Re: Objection to MP08_0244 MOD 1 Modification Request for Mixed Used Development at 23-37 Lindfield Avenue and 11 Havilah Lane, Lindfield

As a resident of Lindfield, I/we wish to lodge an objection against the proposed Modification of the subject development based on the following grounds:

Drawing Title
BASEMENT 3 PLAN

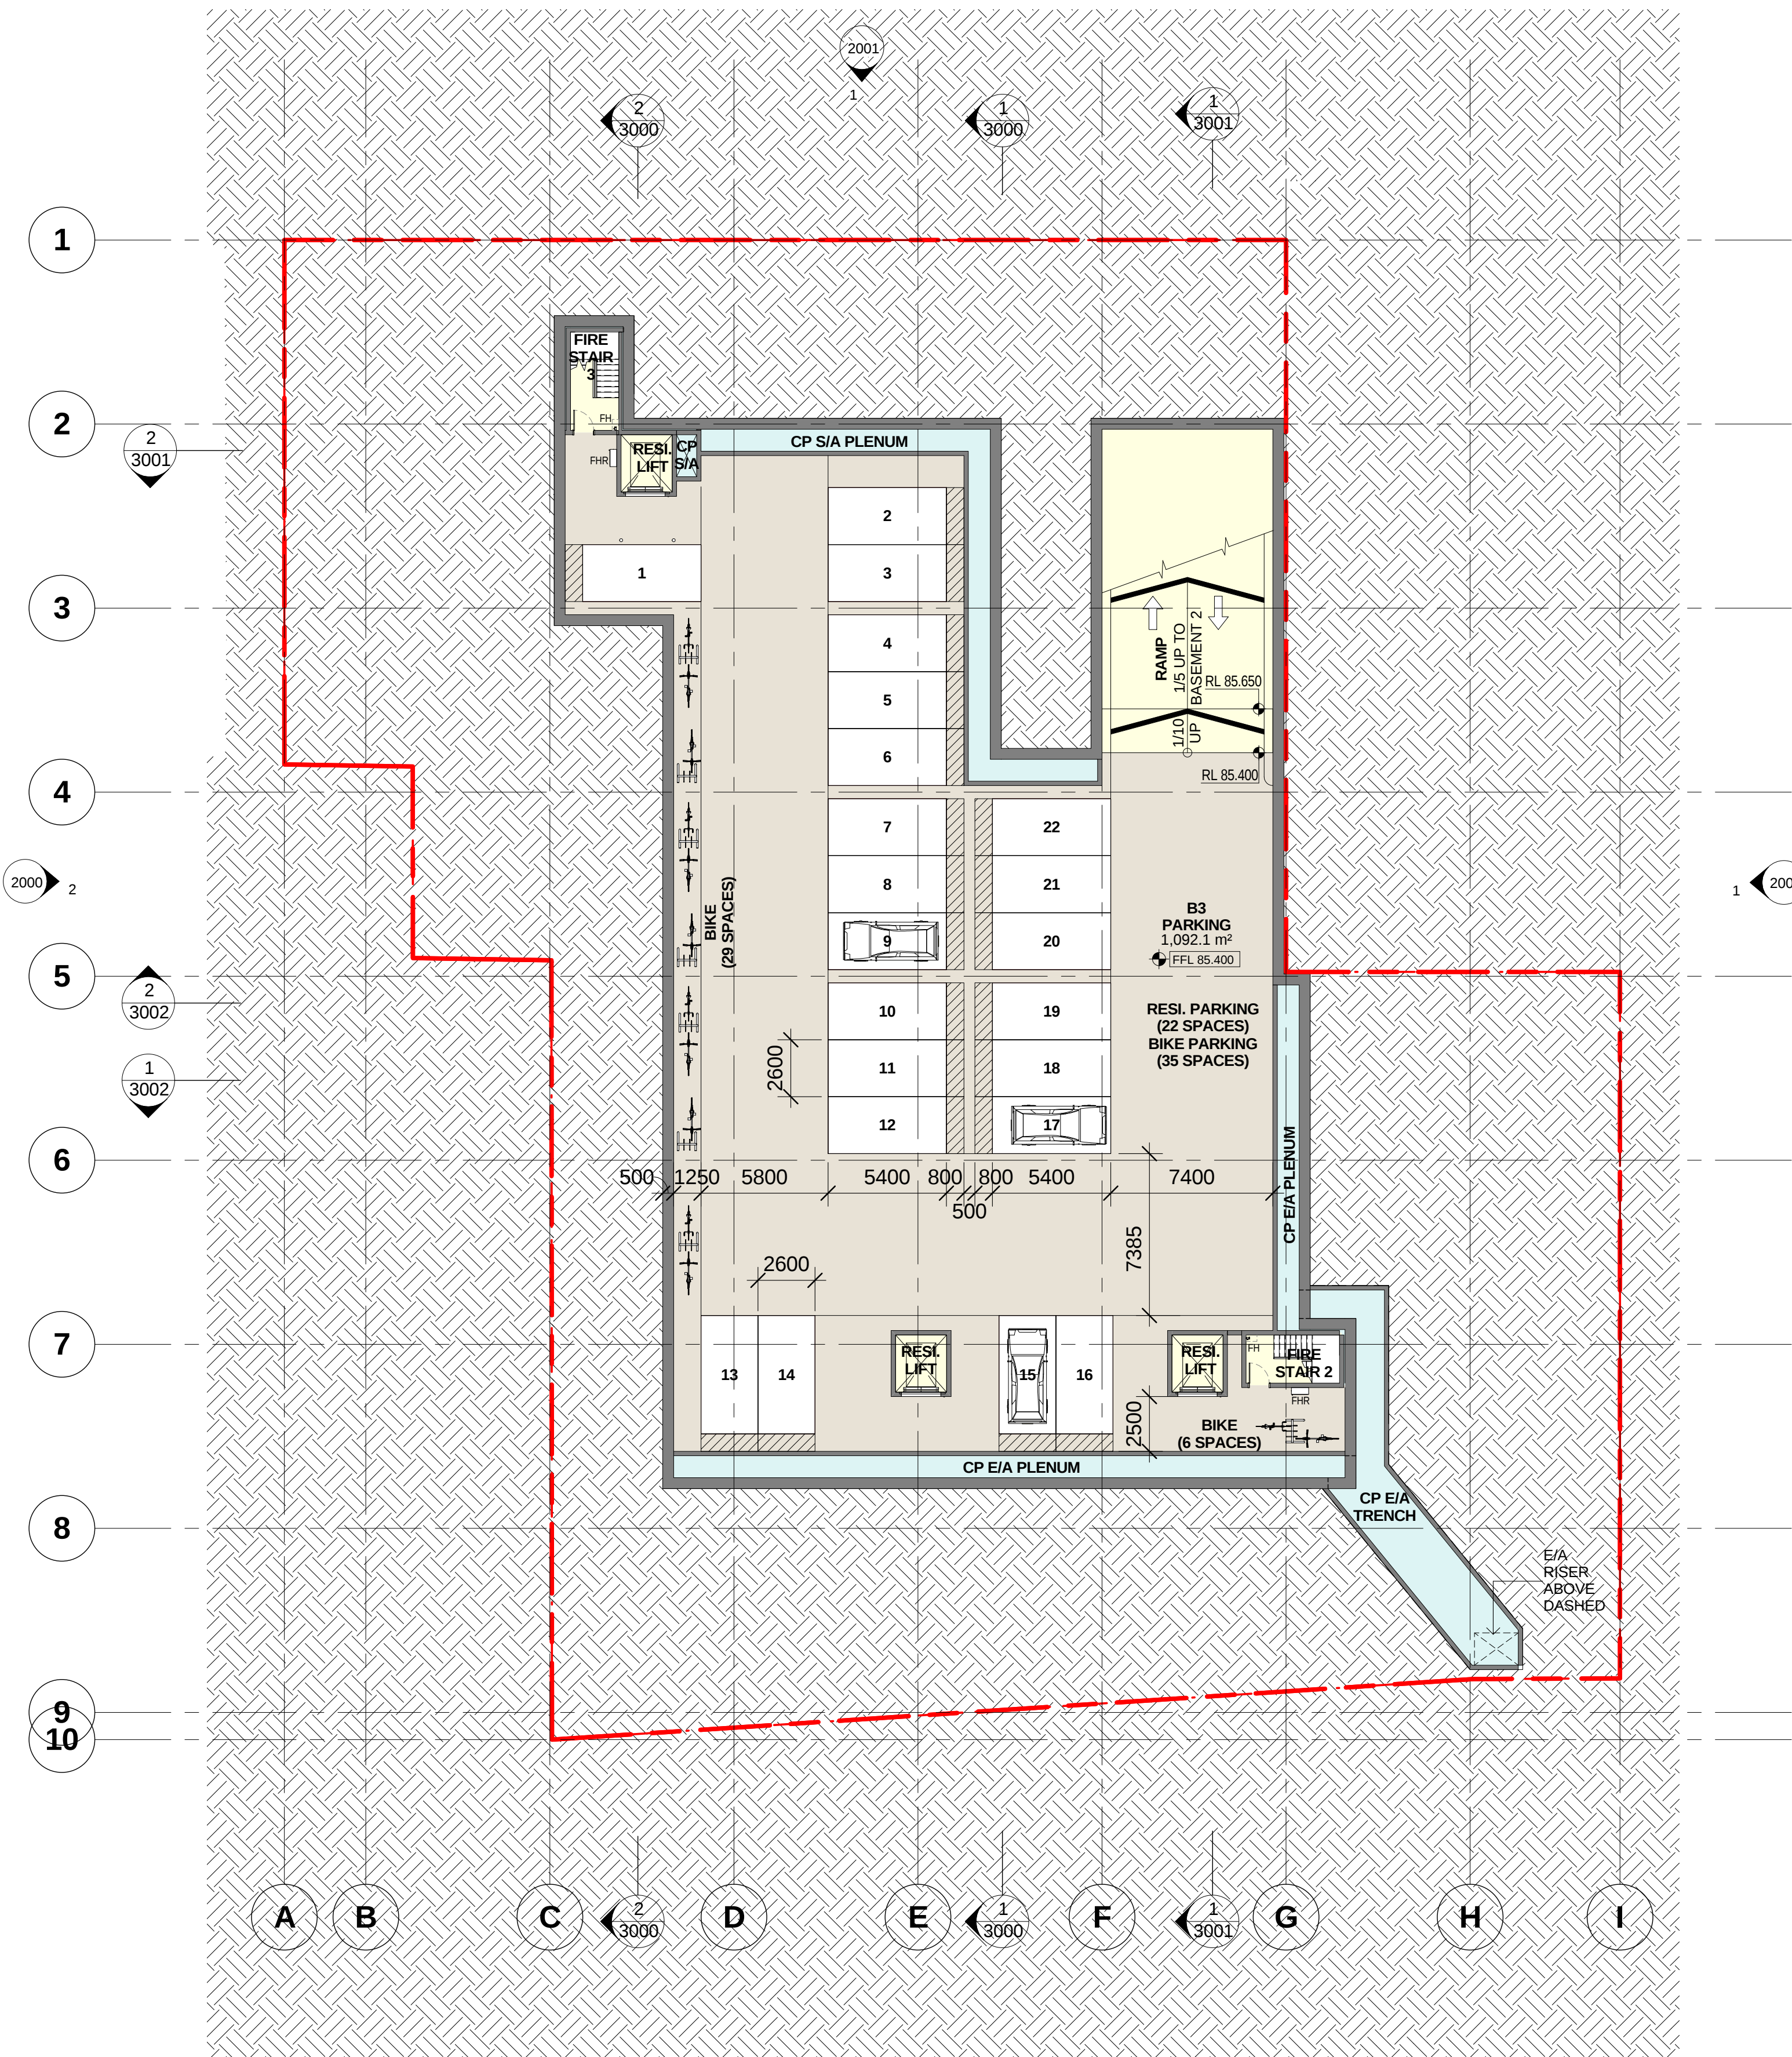
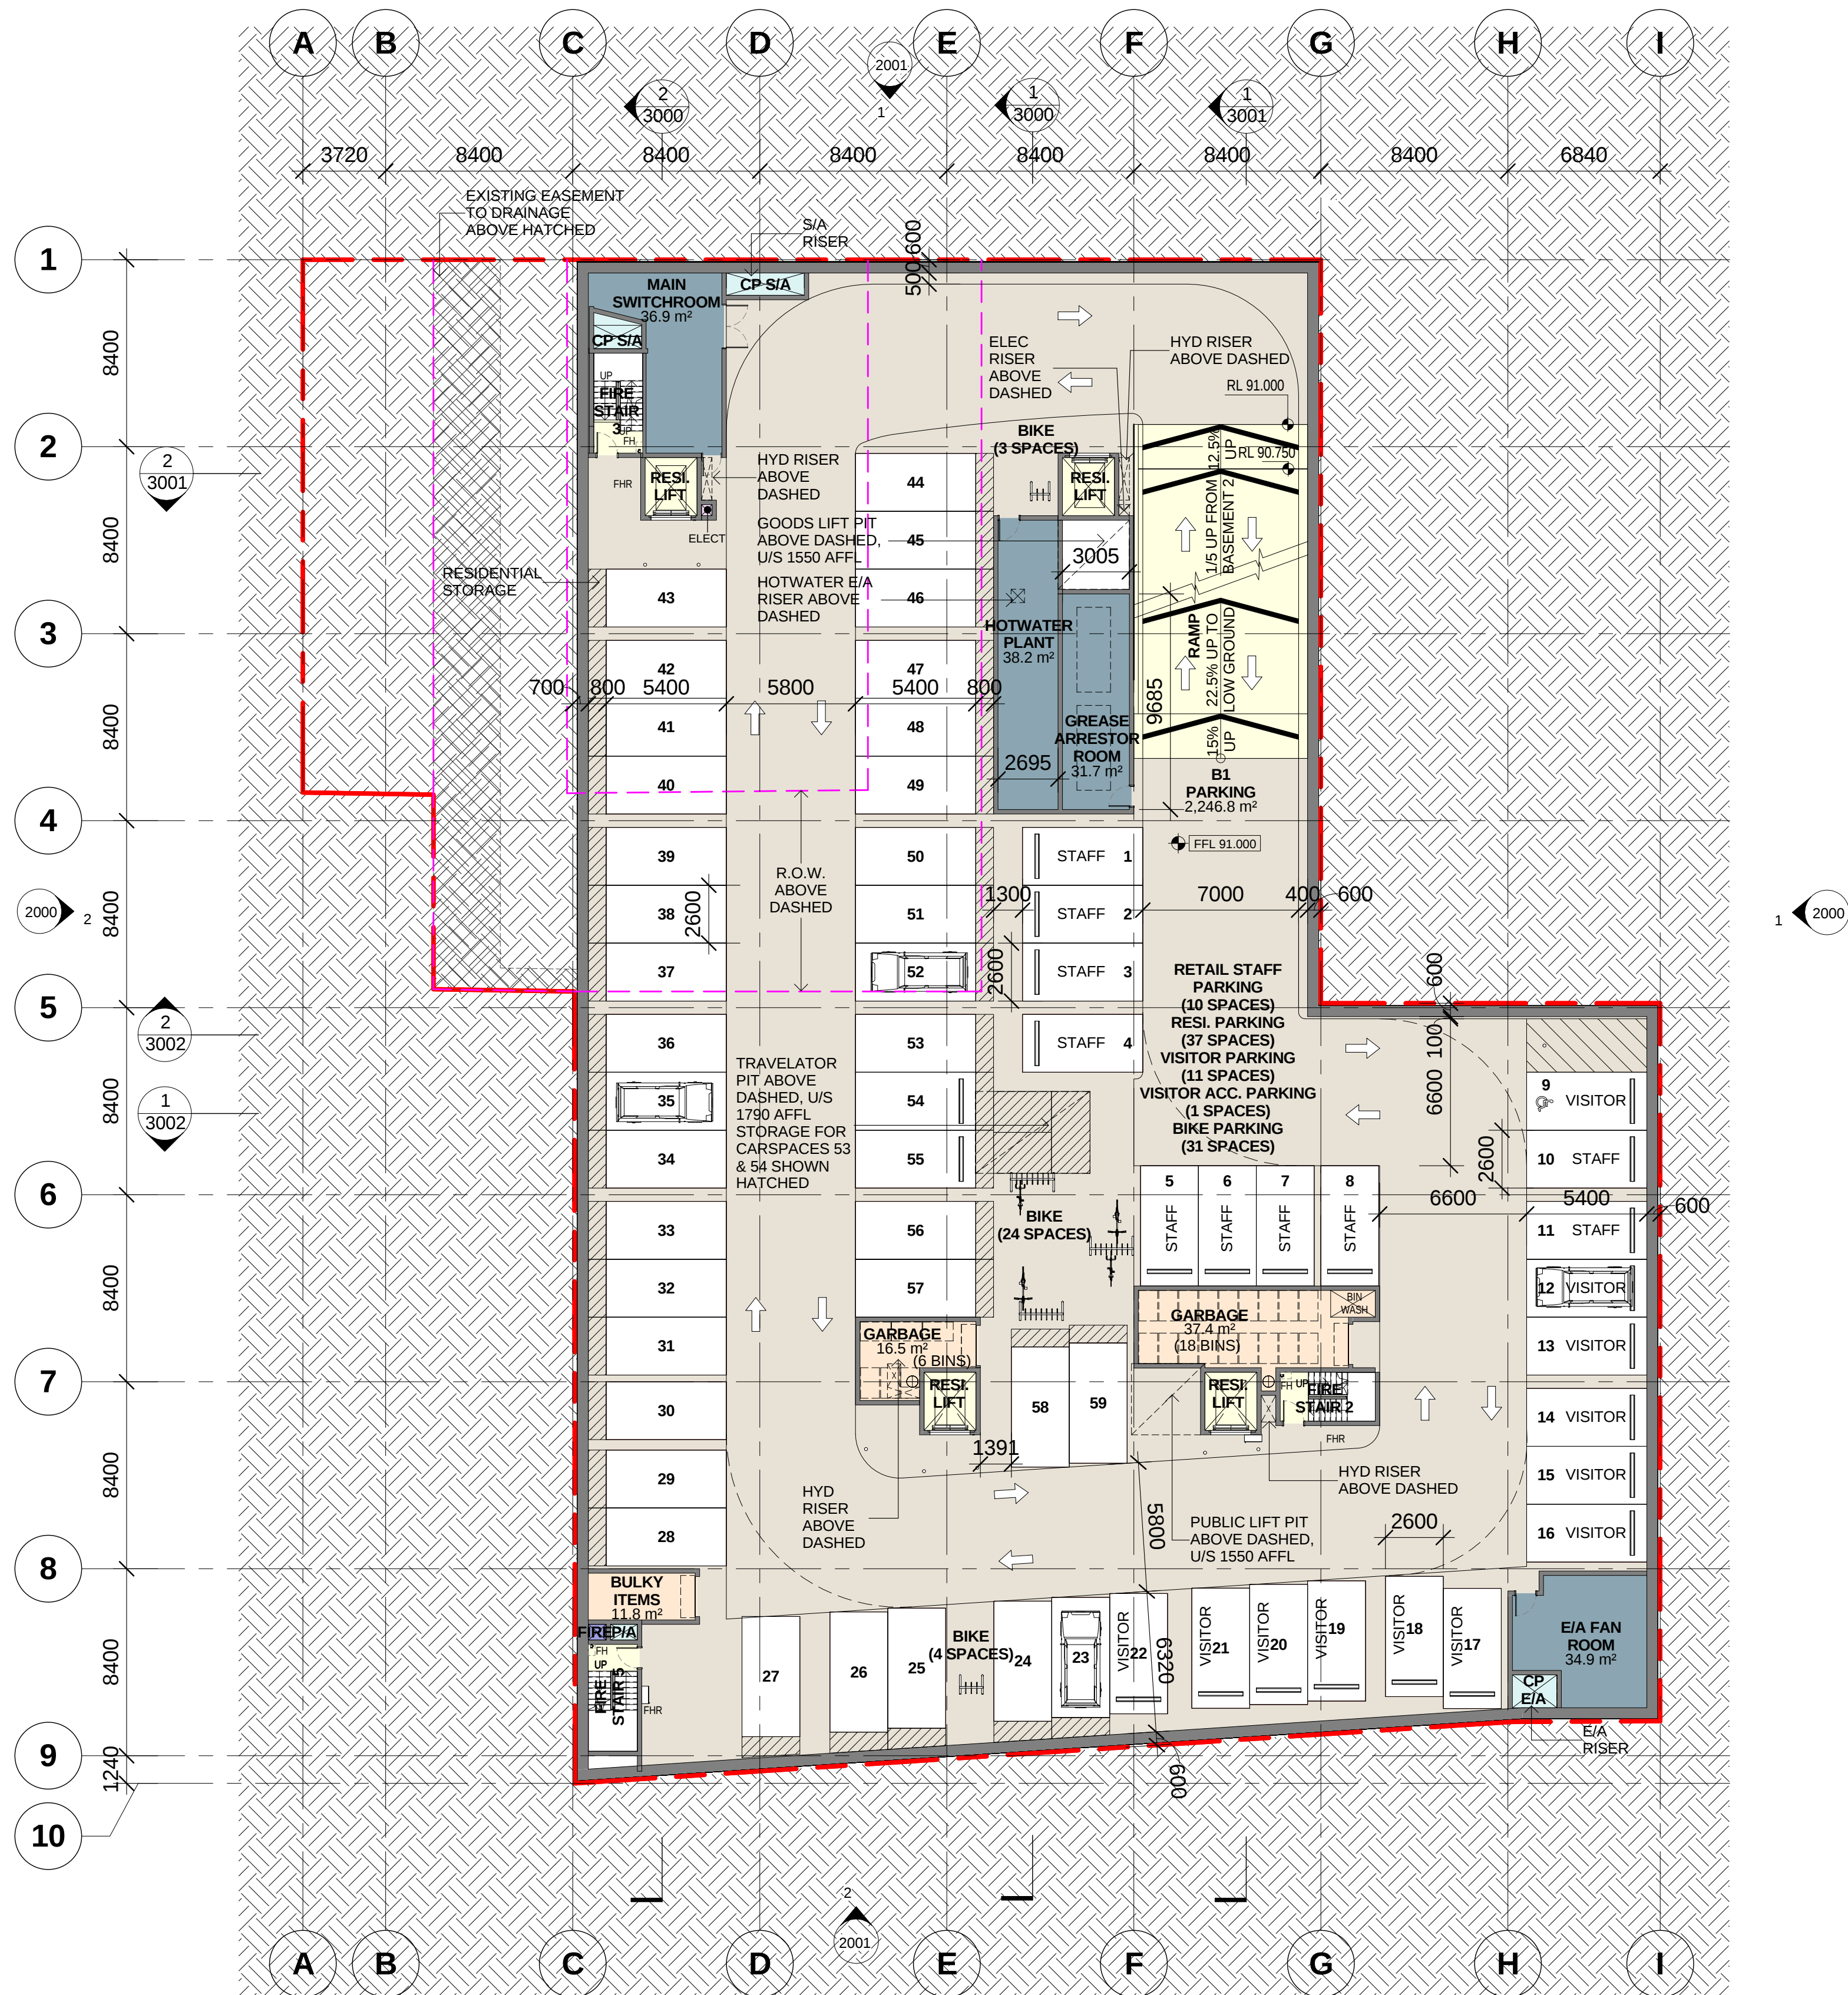
- Car spaces were identified as inadequate for the retail component and this has not been addressed relative to the remaining retail space proposed. The 25 car spaces counted as part of council's car park are also now highly uncertain due to the proposed rezoning and potential redevelopment.
